JOHN HUNTER HEALTH & INNOVATION PRECINCT
SSDA
ARCHITECTURAL DESIGN STATEMENT - RESPONSE TO SUBMISSIONS

RESPONSE TO SUBMISSIONS

ISSUE
AR_C0-B10 B4-00

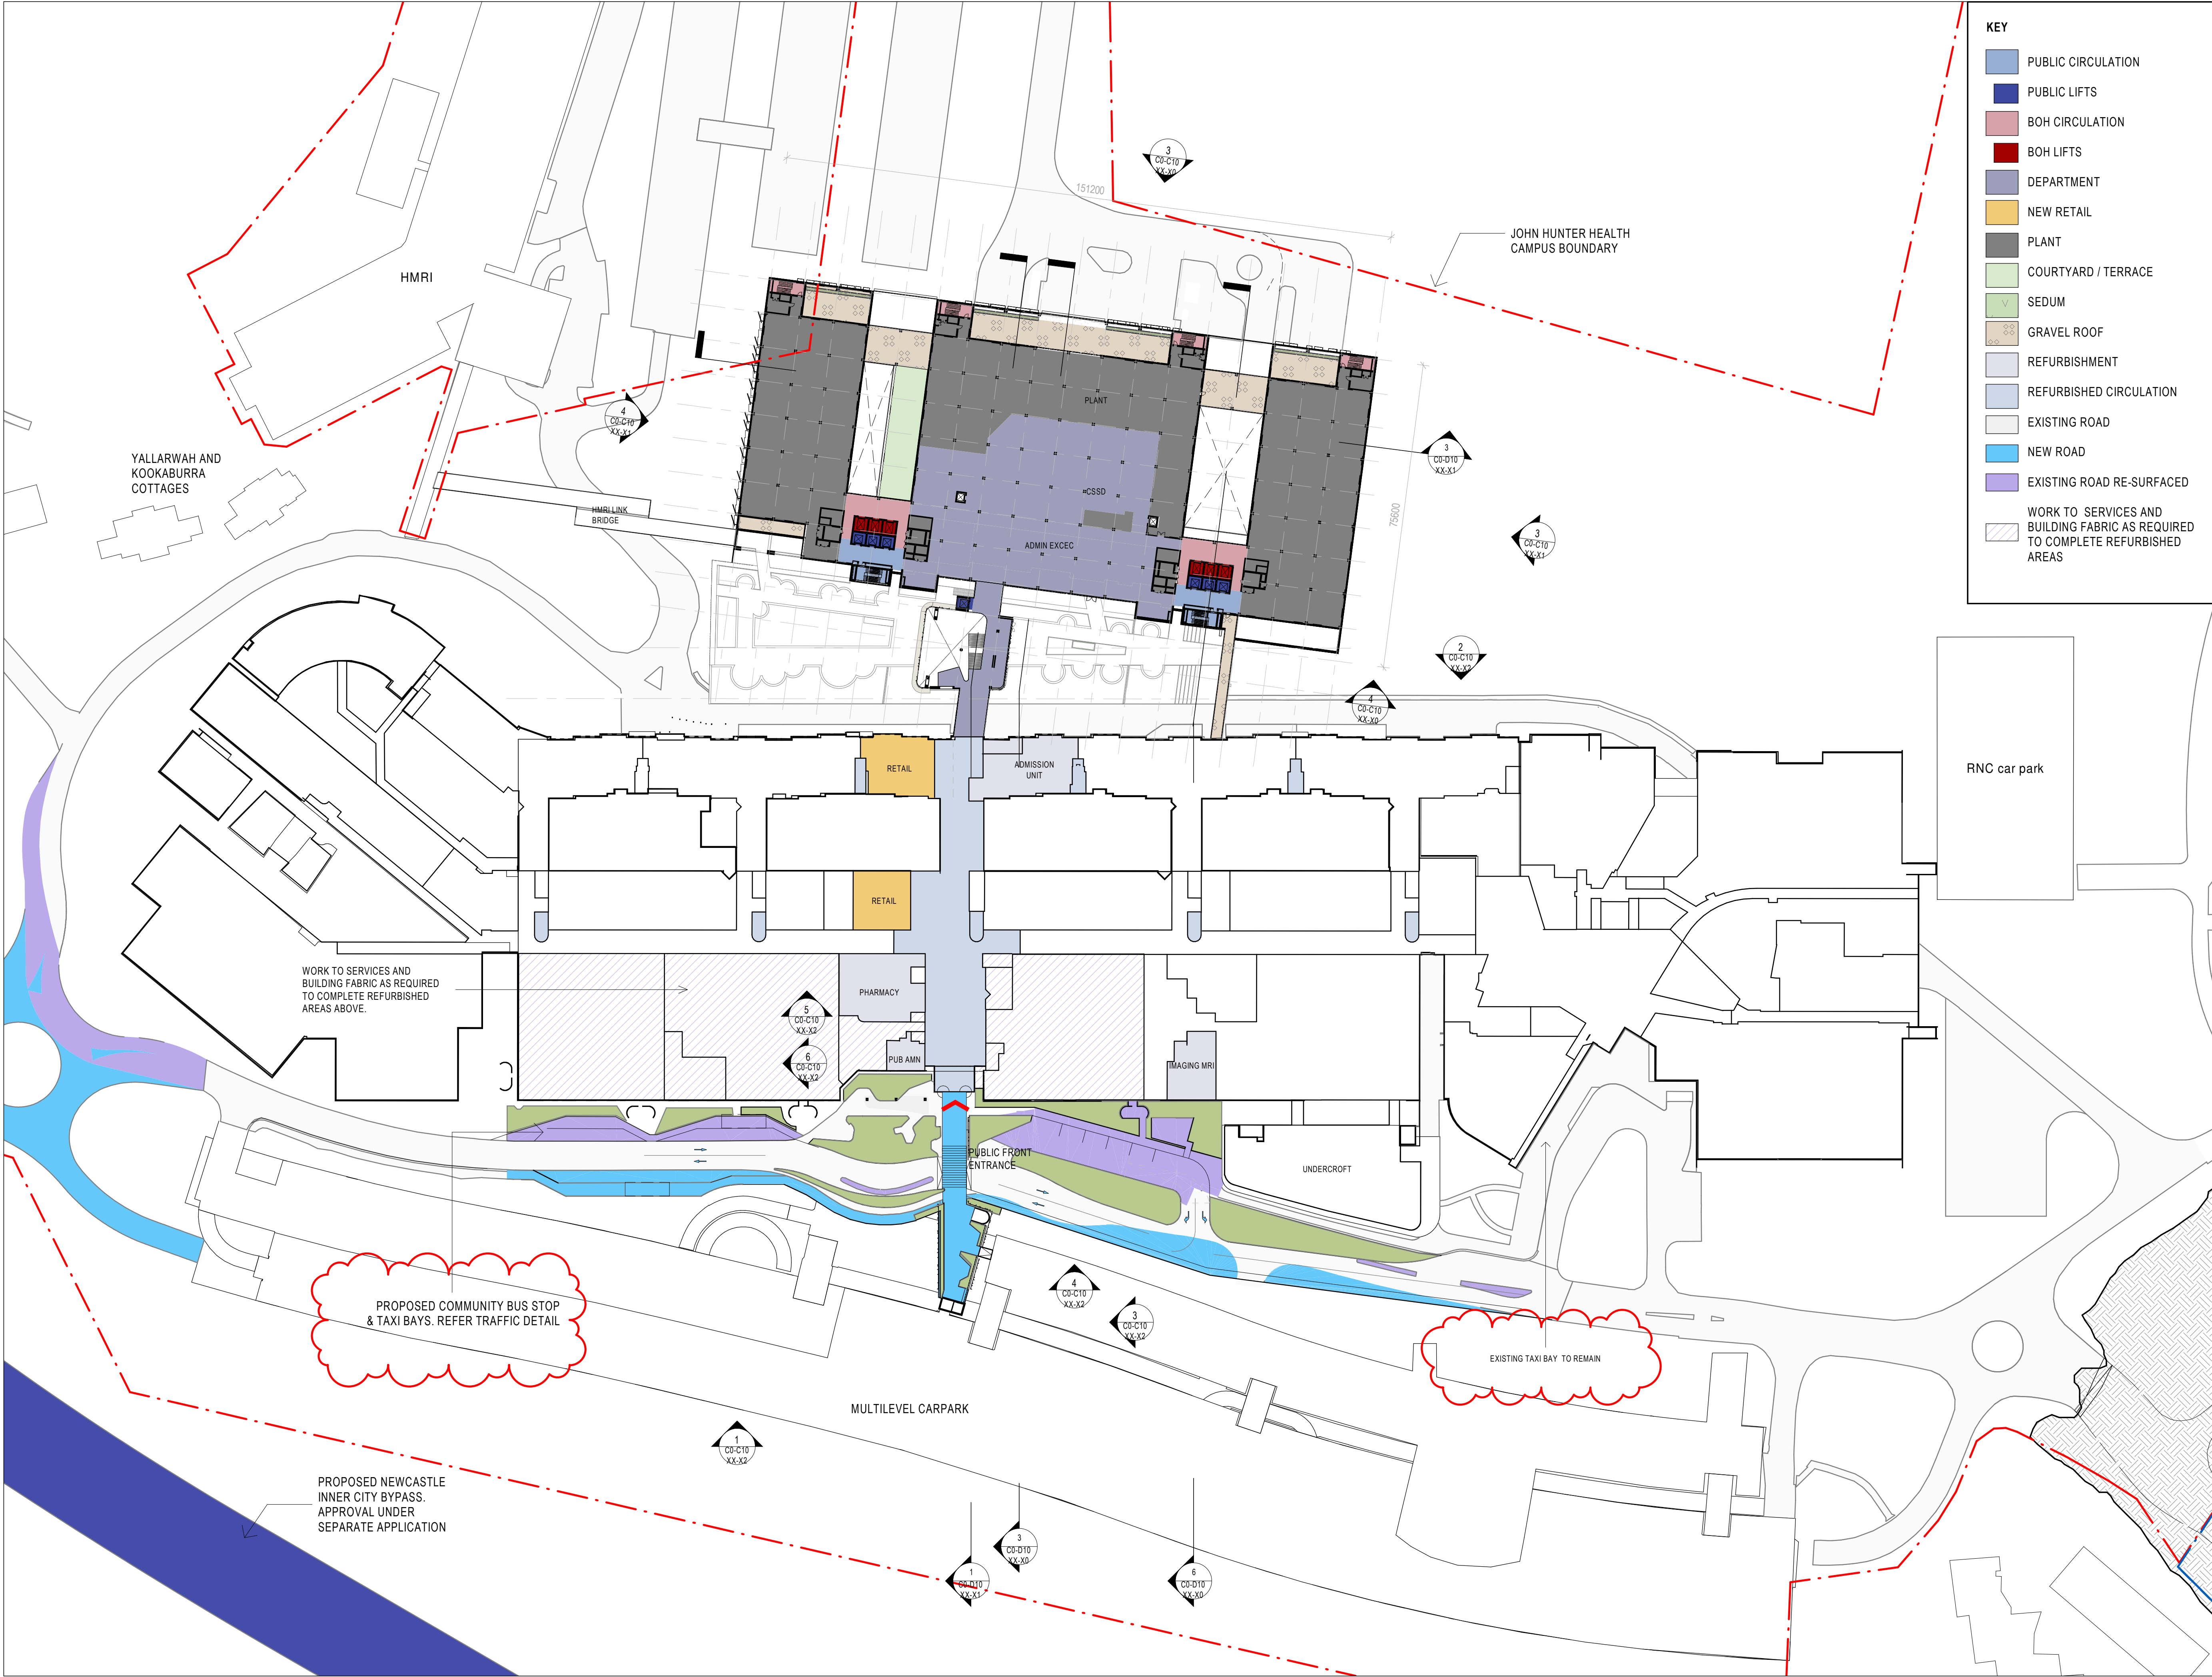
a. Locate bicycle parking and storage facilities in secure, convenient, accessible areas close to the main entries incorporating adequate lighting and passive surveillance and in accordance with Austroads guidelines.	Appended drawings reflect recommendations

b. End of trip facilities should also include lockers, showers and safe bike storage.	Appended drawings reflect recommendations
Transport for NSW	Public Transport Considerations

End of Trip facilities are provided for staff within the semi-basement ASB car park. This location offers ready access to the cycleway through Jesmond Bushland to the north, with immediate connection to the lifts of the ASB. Facility calculations have been determined based on populations for the ASB. Further detail can be found in the appended drawing set - Basement 4 plan.
